22 April 2025

SSD-70817958 DHL Logistics Facility, Badgerys Creek (North)

I refer to the Department's email of 16 April 2025 regarding the Environmental Impact Statement (EIS) for State Significant Development SSD-70817958 DHL Logistics Facility, Badgerys Creek (North) for 'Construction and fit out of two warehouse buildings and ancillary office space, hardstand, loading docks and car parking, landscaping and signage, located within the Burra Park estate' at 1953 - 2109 Elizabeth Drive, Badgerys Creek (Lot 1 DP 1306448) in the Penrith City Council local government area (LGA). Submissions need to be made to the Department by 19 May 2024.

TITLE	GF PLAN - STAGE 2
DATE	08/10/2024
SCALE	1:750 @ A1 1:1500 @ A3
PROJECT NO.	21254
DWG NO.	DA101
REVISION	12

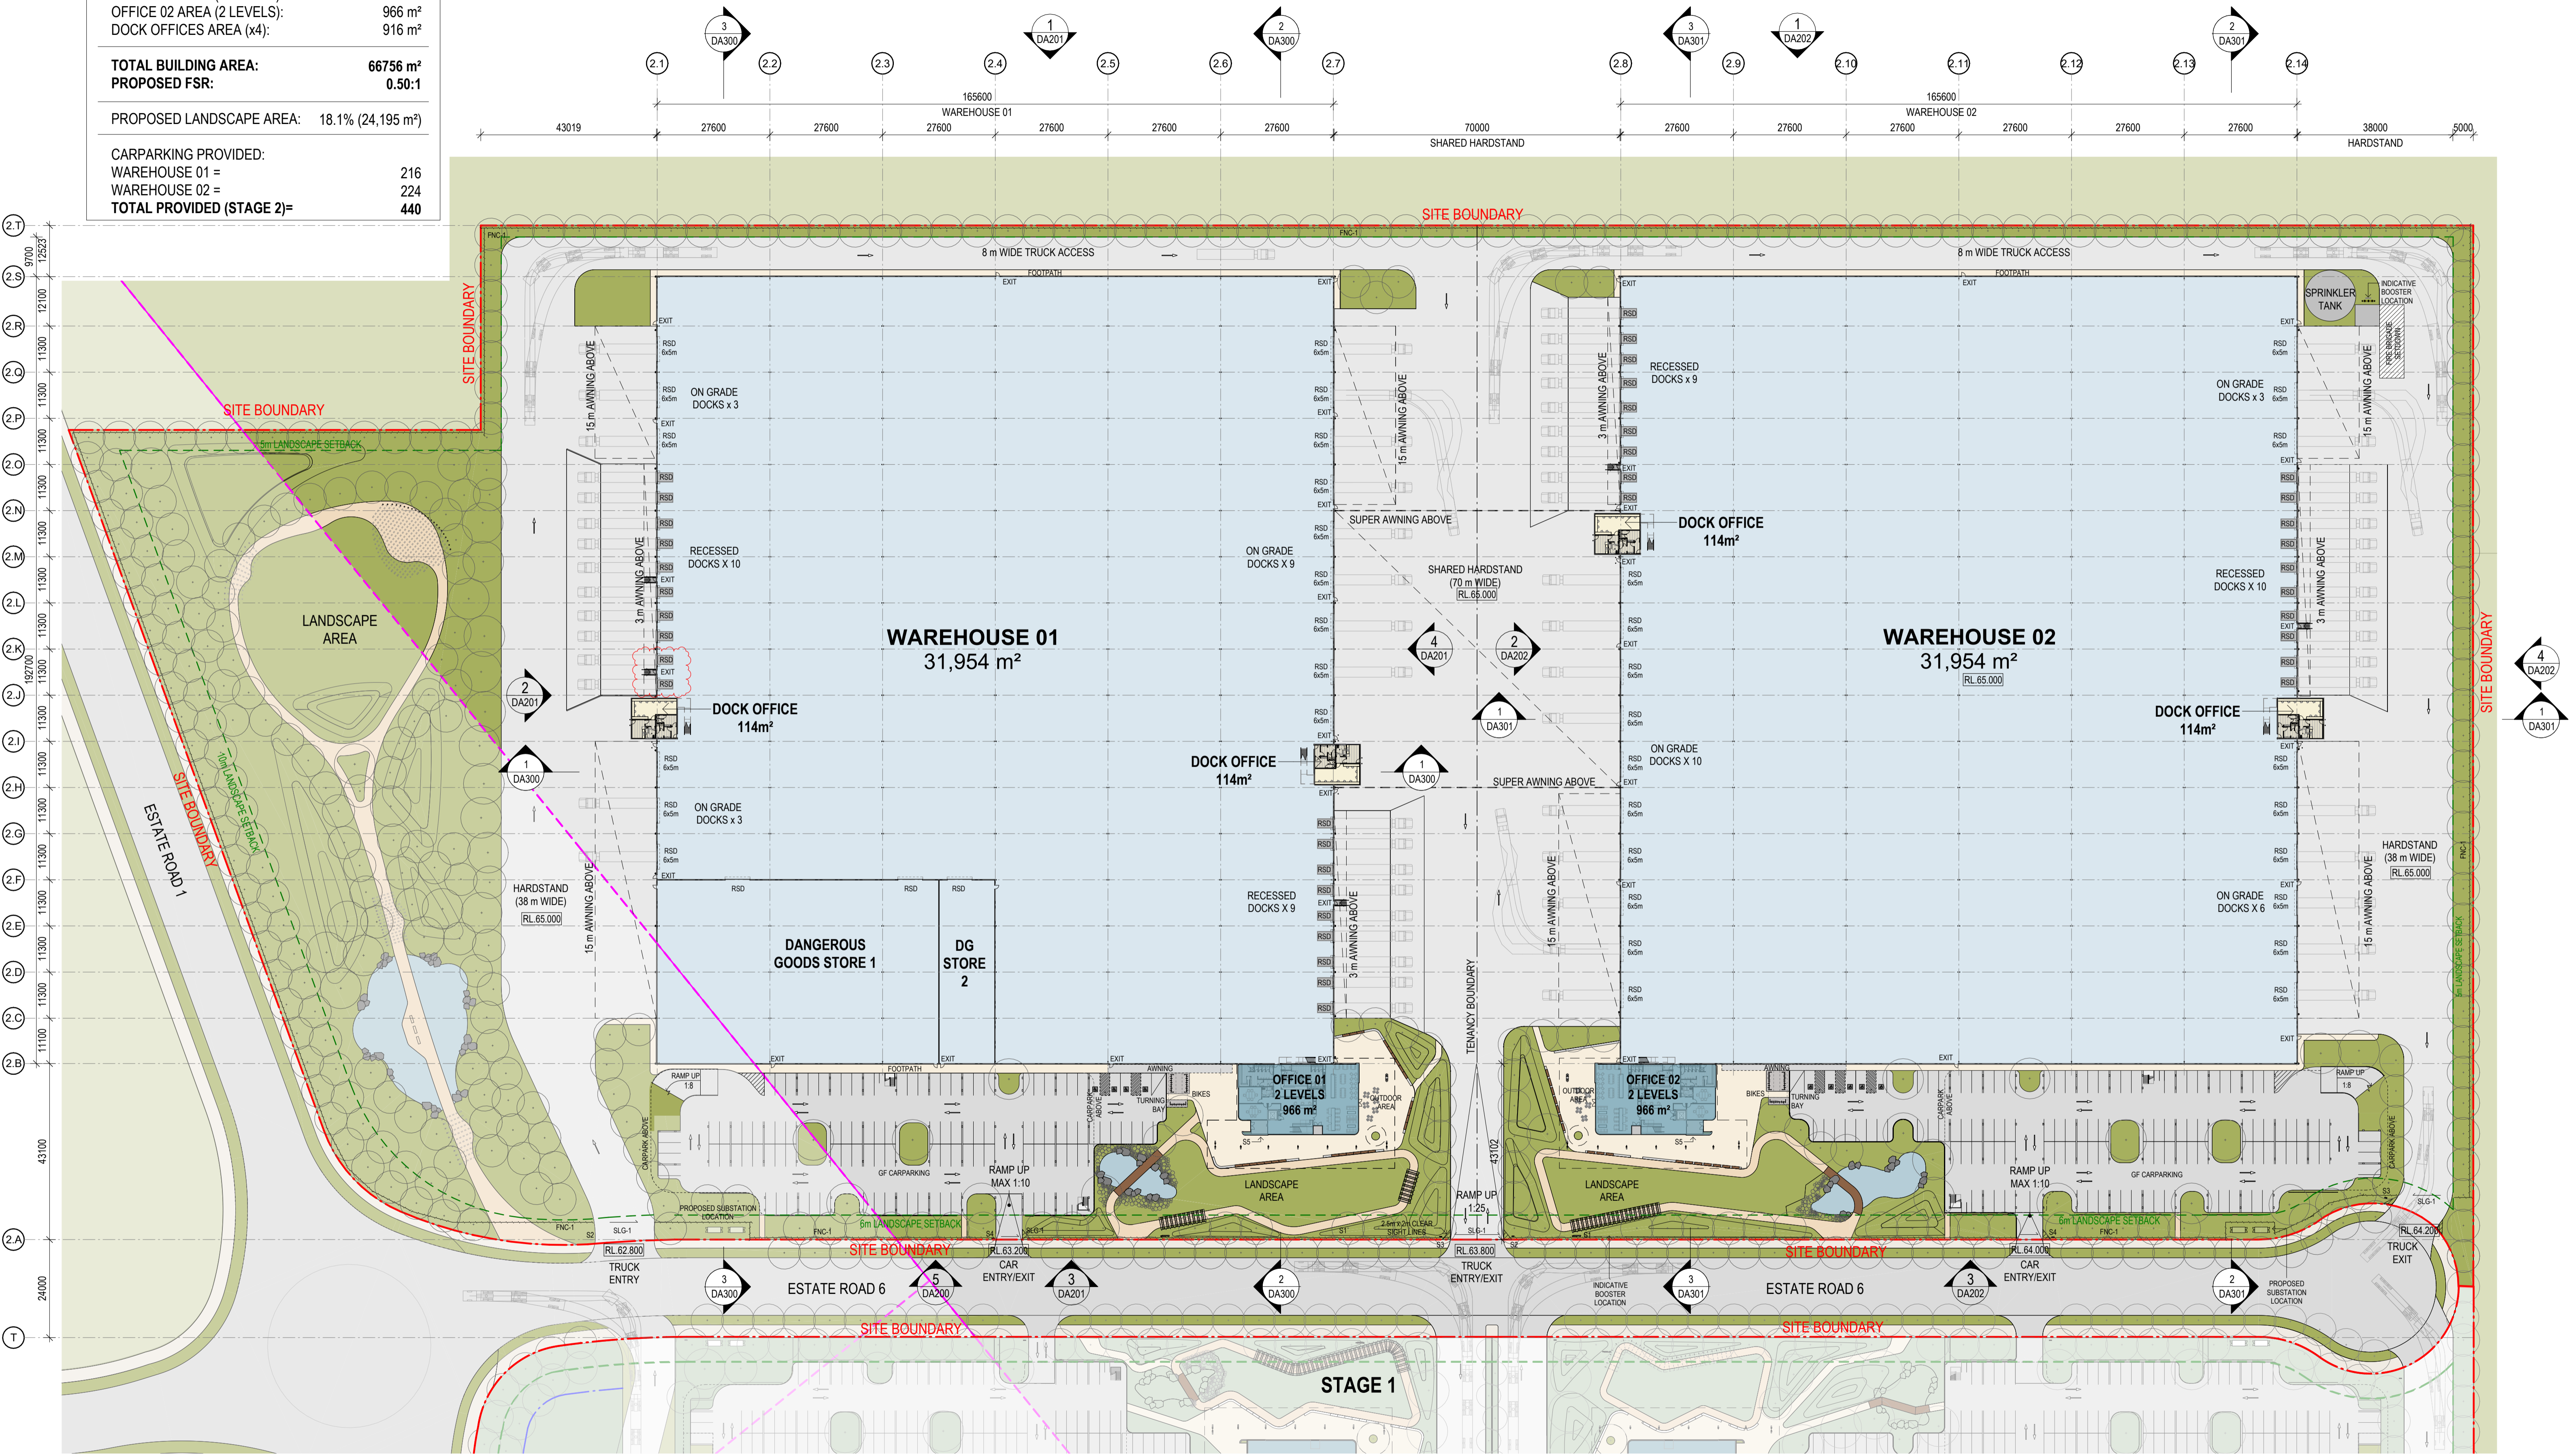
The below copy of the GF Plan – Stage 2 shows two ‘Proposed Substation Location’. Any required padmount substation/s will need to be located within the property (in a suitable and accessible location) and be protected (including any associated cabling not located within a public road / reserve) with an appropriate form of property tenure as detailed in the attached copy of Endeavour Energy’s ‘Land Interest Guidelines for Network Connection’.

Generally it is the Level 3 Accredited Service Provider’s (ASP) responsibility (engaged by the developer) to make sure substation location and design complies with Endeavour Energy’s standards the suitability of access, safety clearances, fire ratings, flooding etc. If the substation does not comply with Endeavour Energy’s standards, the applicant must request a dispensation.
